Our Ref: FP/235/11/

20th December 2011

**Ground floor dining room extension
22 Summerhill Drive Felpham**

EXISTING FIRST FLOOR PLAN

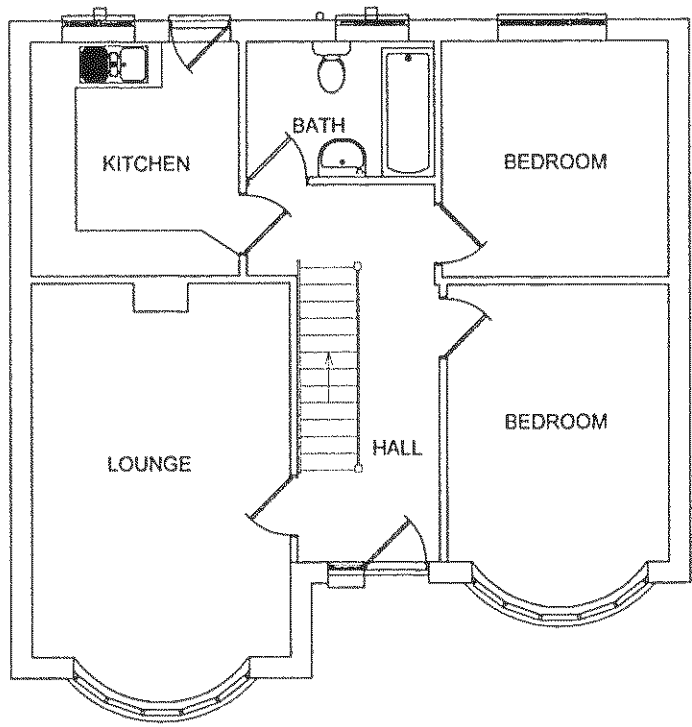
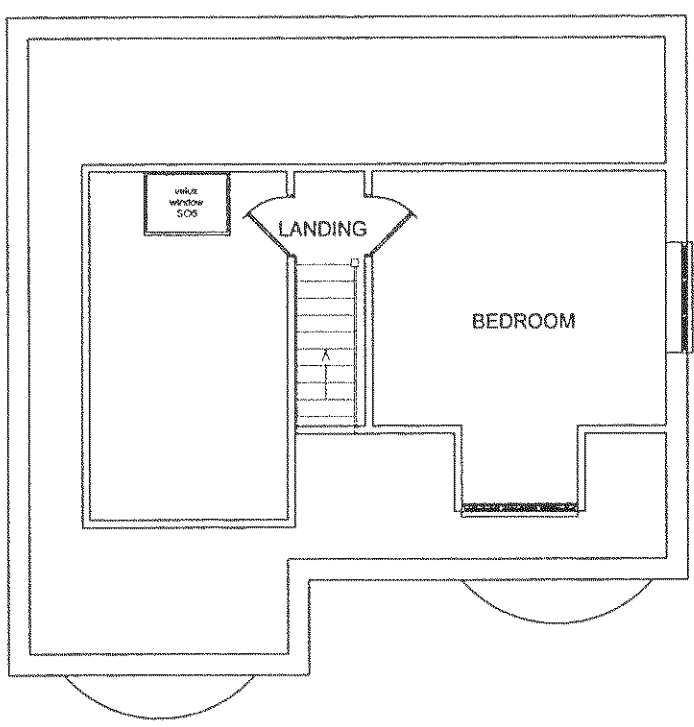
Please provide 1 electronic or 3 paper copies of revised plans. There is a bedroom window shown on the existing and proposed south elevations which is shown on the north side on the existing and proposed first floor plans. Please amend.
